COUNCIL SUBMISSION – Sydney Metro West - Parramatta Metro Station - Over and Adjacent Station Development EIS (SSD- 35538829) - public consultation

EXECUTIVE SUMMARY

PARRAMATTA METRO OSD			
PARRAMATTA STATION ARCHITECTURE			
Building C - B1 + Ground			
FILE No:	SHEET: OF	©	
STATUS: POC	EDMS No:	REV	VER
DRG No:SMWSTEDS-SMD-PTA-DRG-AR-03.201	6

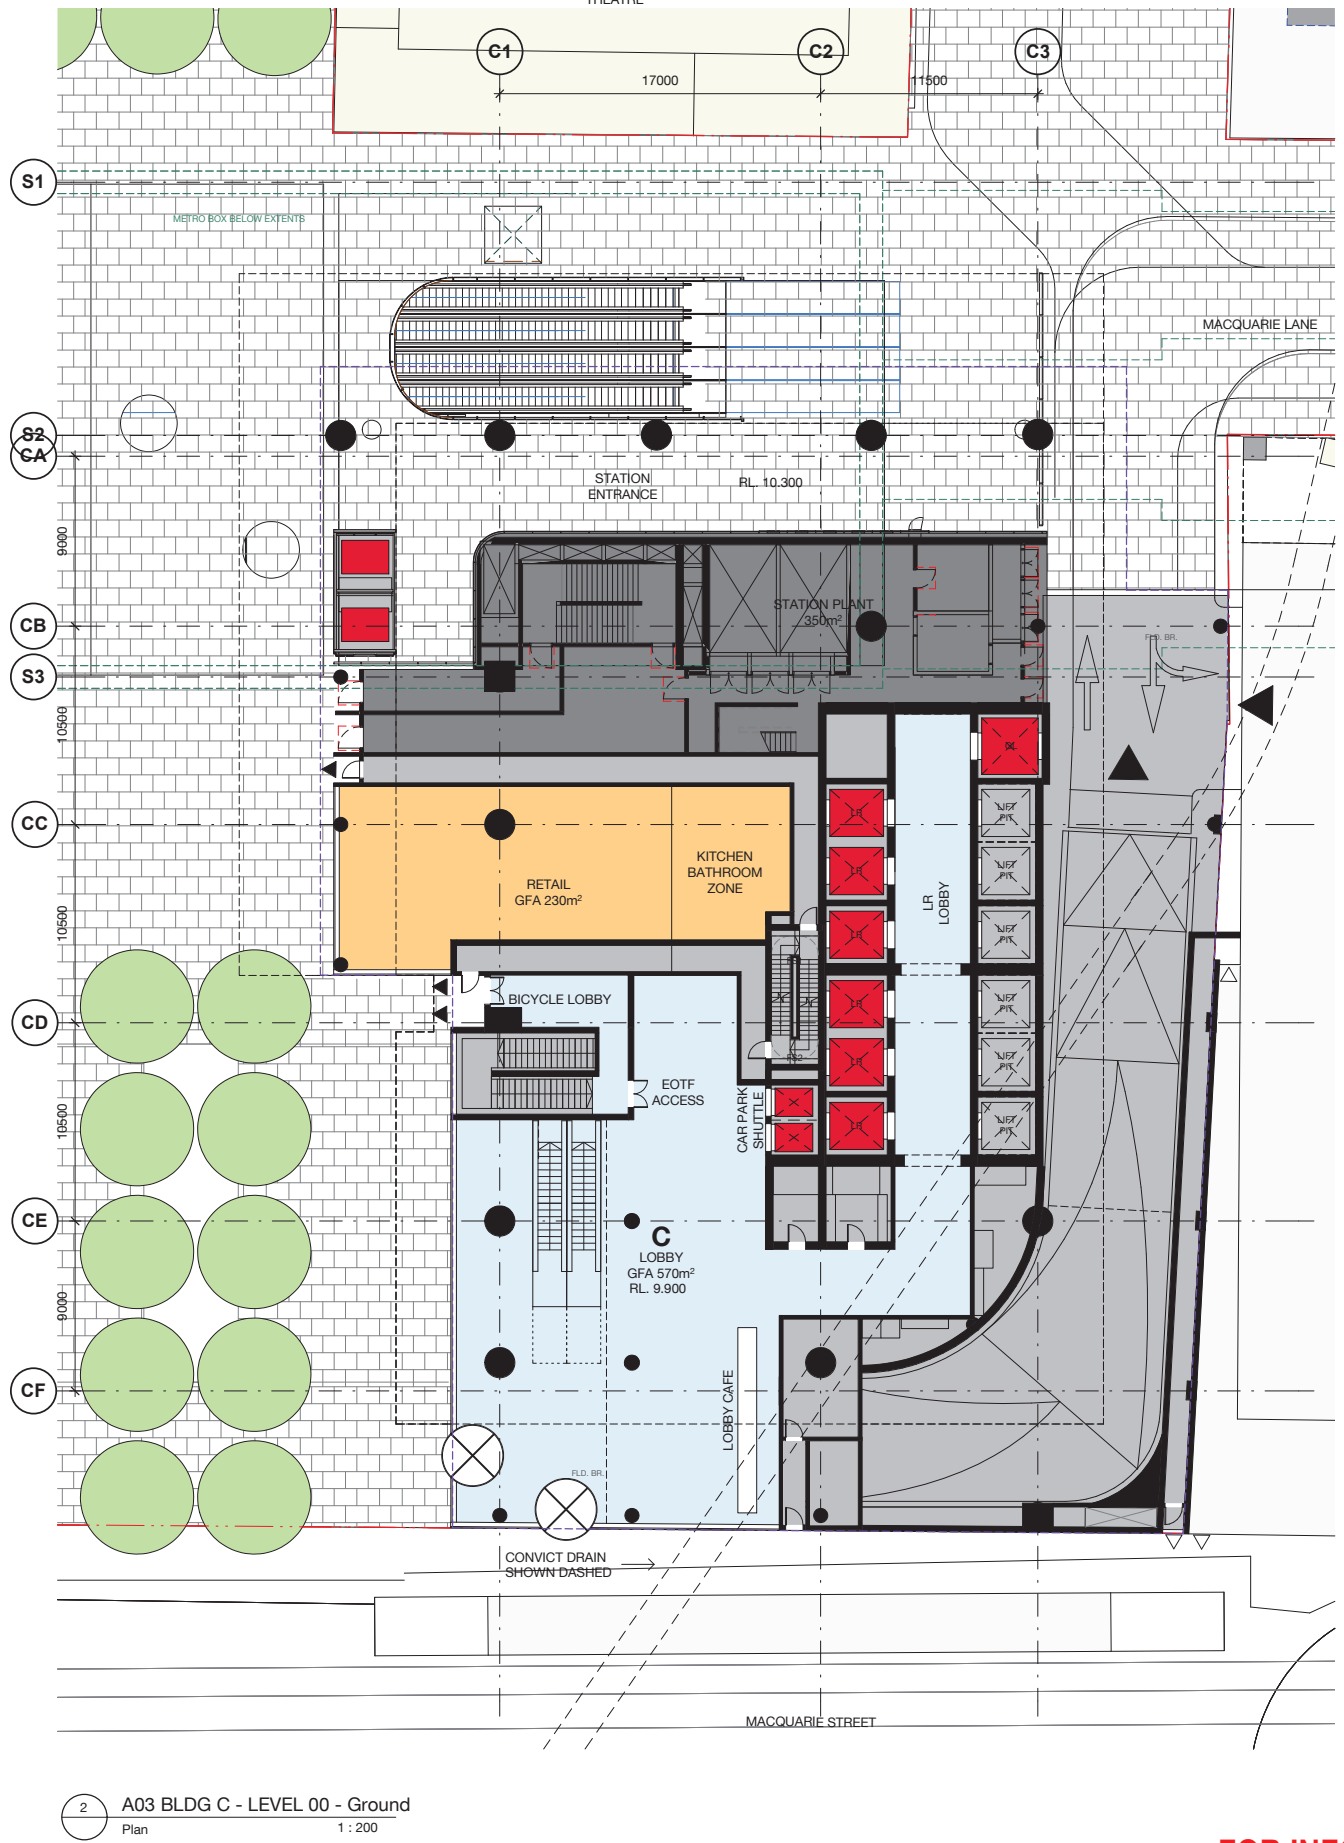
- Building C relationship to the Roxy and Macquarie Lane – There is not sufficient information describing the building podium and station entry structure and canopy. The EIS documentation varies in the location of the eastern Metro entry with some drawings showing it within Building C and others within the extension of Macquarie Lane. A canopy over the entry is also shown in some drawings. Neither is sufficiently defined in the Building Envelopes or addressed in the Design Guidelines. The proximity to the Roxy as a State heritage item and pedestrian volume requirements for the laneway are also not addressed. Council's DCP include heritage objectives and controls to define a 6 storey podium setting to the Roxy. This is not addressed, and an adequate alternative solution is not proposed.

- Building C setback to Macquarie Street – Council's DCP includes a 2m setback to Macquarie Street to improve pedestrian circulation around the light rail stop.

Sydney Metro west should to address the future opportunity of the Roxy Theatre to have an active frontage to Macquarie Lane

Sydney Metro West need to consider the requirement for Roxy Theatre to have an active frontage to Macquarie Lane in their planning and in relationship to their station entry, structure and building C canopy.
